Application No MP09_0068

I am writing in response to the submitted Architecture and Building Works Pty Limited Environmental Assessment (EA) for the above project regarding the development of the former Rachel Forster Hospital site at 134-144 Pitt Street Redfern.

1 NORTH ELEVATION BUILDING 1
SCALE 1:200

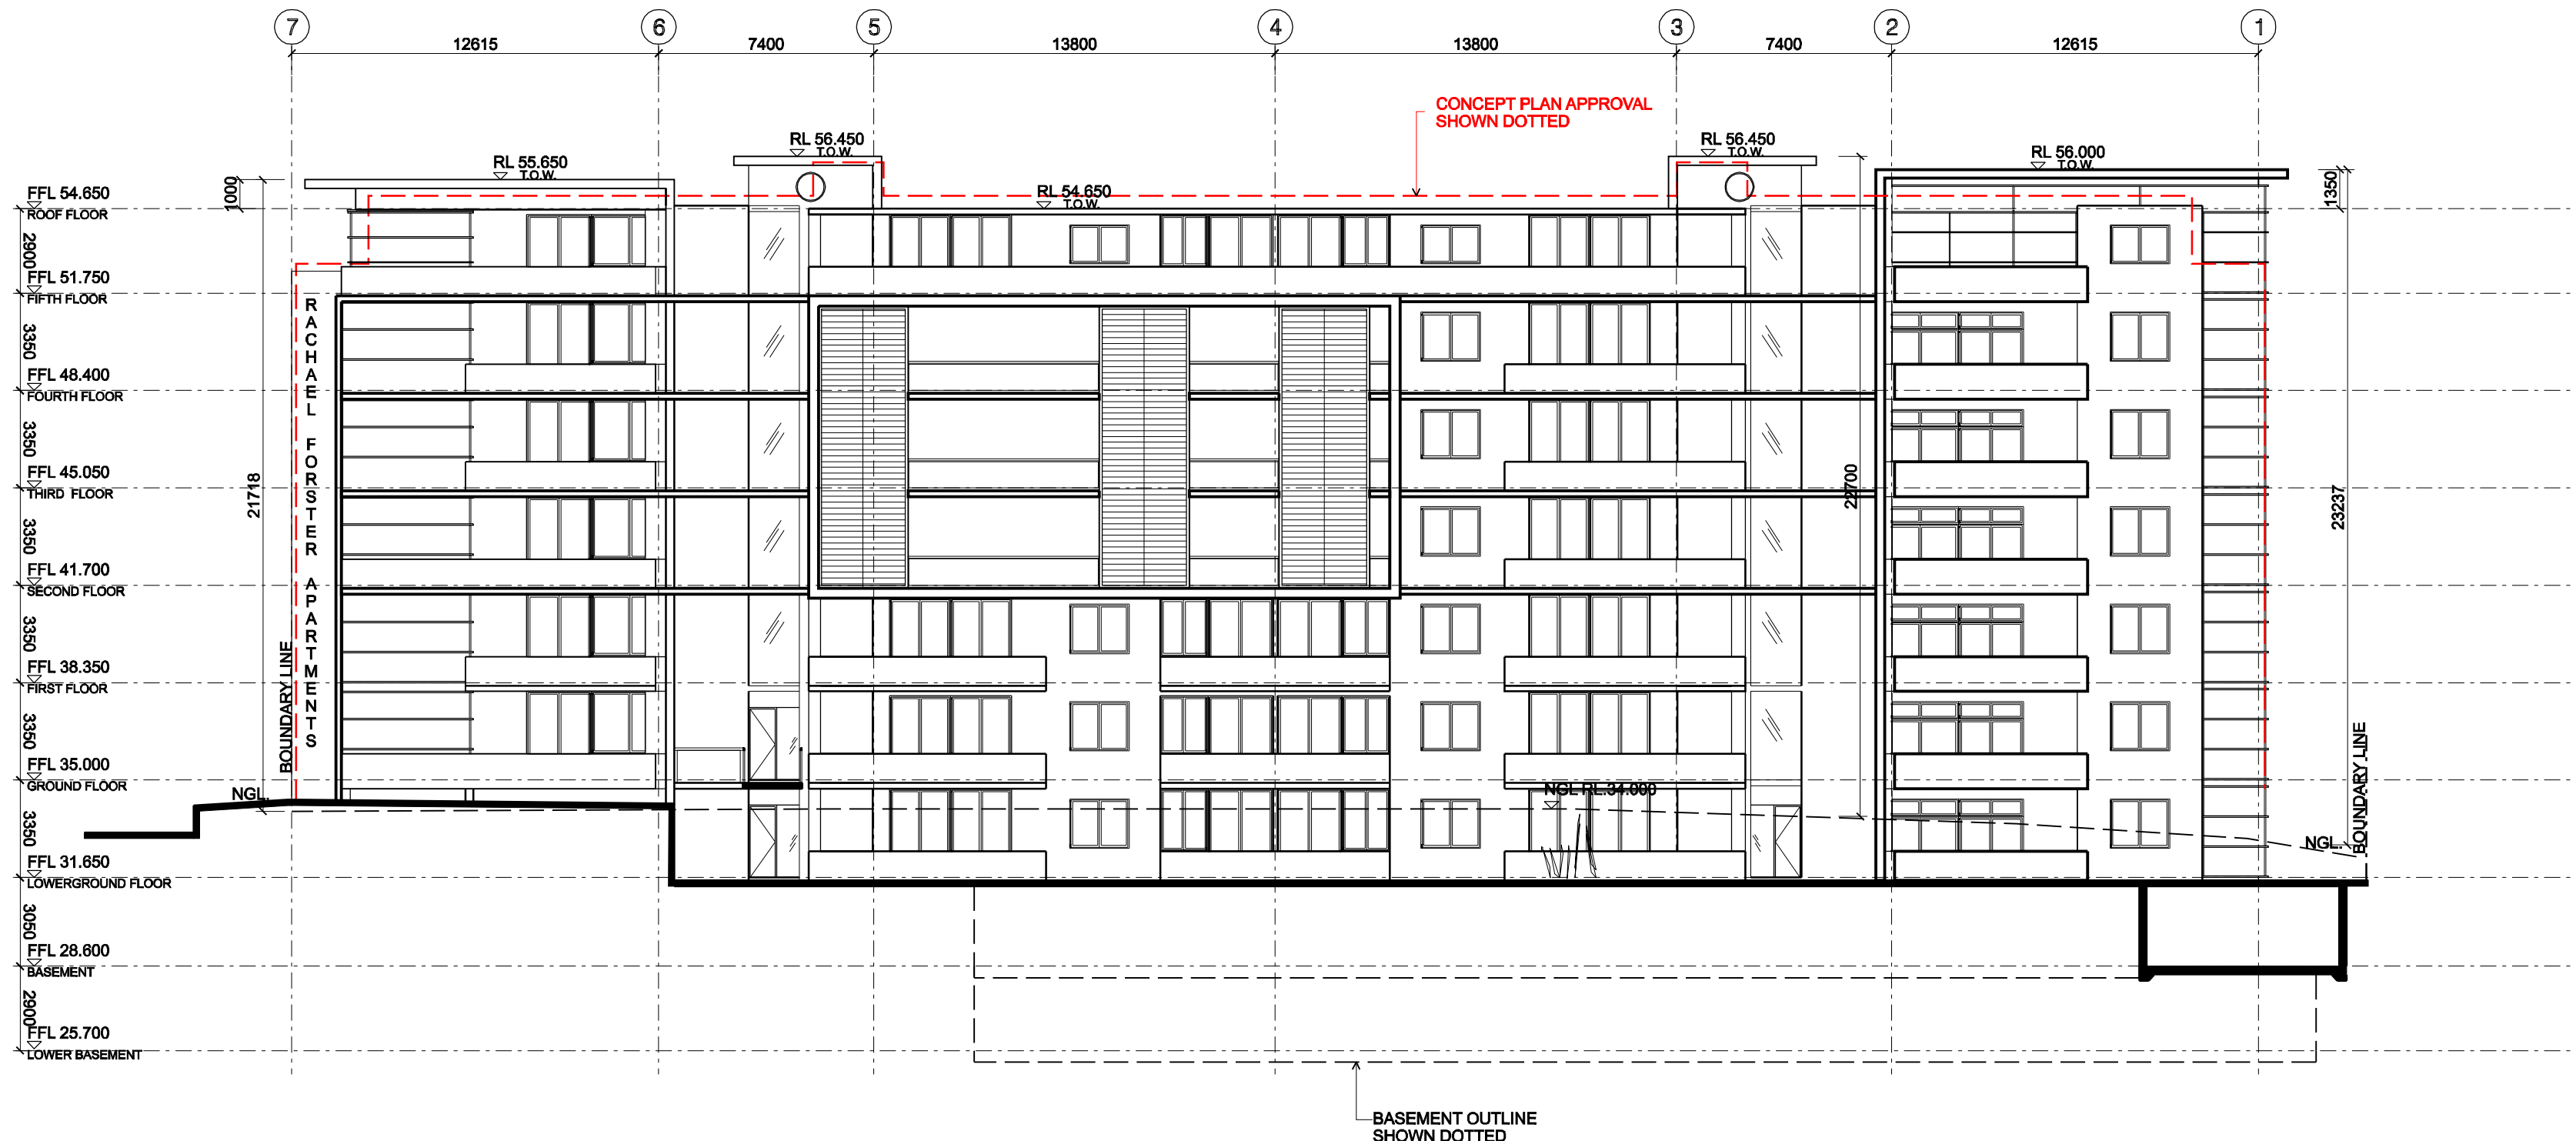
My immediate concerns relate to the number of apartments planned for the northern boundary of the site, that is, Albert Street. My understanding is that the developer intends to construct 46 north facing residential units comprising of 20 x 1 bedrooms and 26 x 2 bedrooms, all with balconies. The existing housing situated directly opposite the proposed development is characterised by 10, essentially 100+ year old two story terrace dwellings.

I believe with this number of apartments, the level of privacy to all present terraces on Albert Street will be obliterated if this development proceeds.

The proposed development lacks any spatial planning and is deficient in any consideration towards the current neighbourhood sensibility. The majority of the proposed 46 apartments would be able to see directly into the bedrooms and living areas of all existing terraces on Albert Street. I foresee a total loss of privacy if this overdevelopment of the site proceeds. Not only will the structure be an eyesore it will be out of scale and out of character in terms of its appearance compared with existing residential properties in the vicinity. I am also concerned that with the proposed increase height of the structure on the northern boundary, residents on Albert Street will lose their cherished current view of blue sky from their living spaces.
